Application Ref: 76478/APP/2021/2871

REFUSAL OF PLANNING PERMISSION

Application number:	76478/APP/2021/2871
Date your planning application was submitted:	22nd July 2021
Site location:	245 Park Road Uxbridge UB8 1NS
Description:	Two storey front extension
Application submitted by:	Mr Alex Frame
Plans that this decision was based on:	See attached Schedule of Plans

Development: Two storey front extension

*Proposed Ground Floor
No. 245*

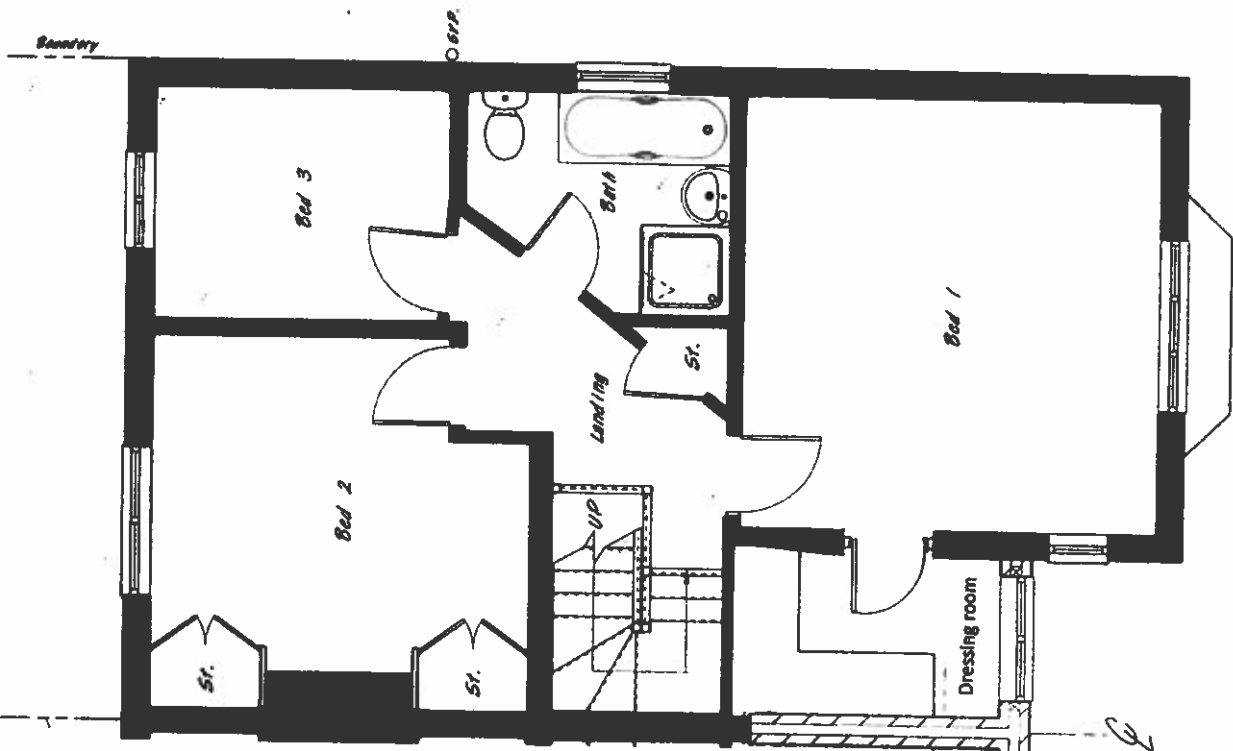
The proposal seeks permission for a two storey front extension would infill part of the recessed section of the front facade. The extension would measure approximately 1.8 m in depth, 1.4 m in width and would be characterised by a pitched roof measuring 3.14 m. The two storey scale of the extension would be considered contrary to the principles of DMHD 1 which seek to ensure that extensions are modestly designed and subordinate to the main dwelling. The proposed extension would be visibly at odds with the design and appearance of the subject building, forming an illogical and alien addition to the front of the property. Furthermore the crown roof design would be inappropriate and would result in a roof form which is at odds with the character and appearance of the street scene and the architectural composition of the existing property. Whilst it is noted that the an application for the same development at No 245 has been submitted this proposal would result in an imbalance of symmetry between the two properties if the application at No 245 were not to be implemented.

SITE: 245 Park Road, Unbridge, UB8 3NS	DRAWN:	SCALE:	DATE:
	DAE	1:50 @ A3	April 21
	DRAWING NO:	21/191/94	REV: A

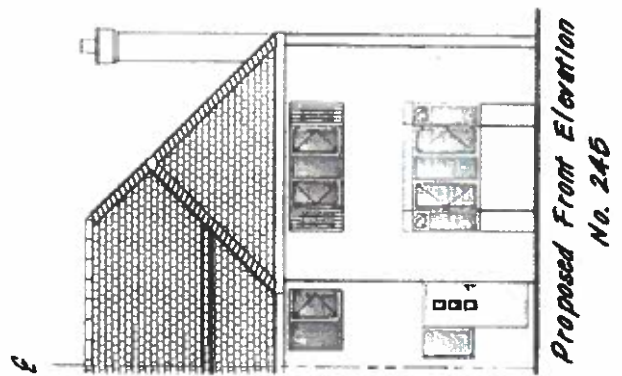
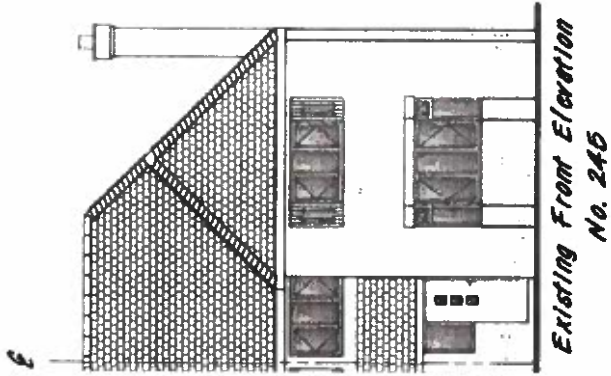
No.243 is the adjoining property which forms the pair of semi's and is therefore the principle property which needs to be considered. Both properties feature a recessed section in the front elevation which would be infilled by the proposed extension. Whilst when viewed in isolation the proposal would extend beyond the recessed section of the front elevation of neighbouring property this would extend beyond the door and the window which serves the hallway above the door. There would be no material loss of light or outlook.

The proposed extension, by reason of its size, scale, bulk and design, would fail to harmonise with the architectural composition of the original dwelling and would be detrimental to the character, appearance and visual amenities of the street scene and the surrounding area. Therefore the proposal would be contrary to Policy BE1 of the Hillingdon Local Plan: Part One - Strategic Policies (November 2012) and Policies DMHB 11, DMHB 12 and DMHD 1 of the Hillingdon Local Plan: Part Two - Development Management Policies (January 2020).
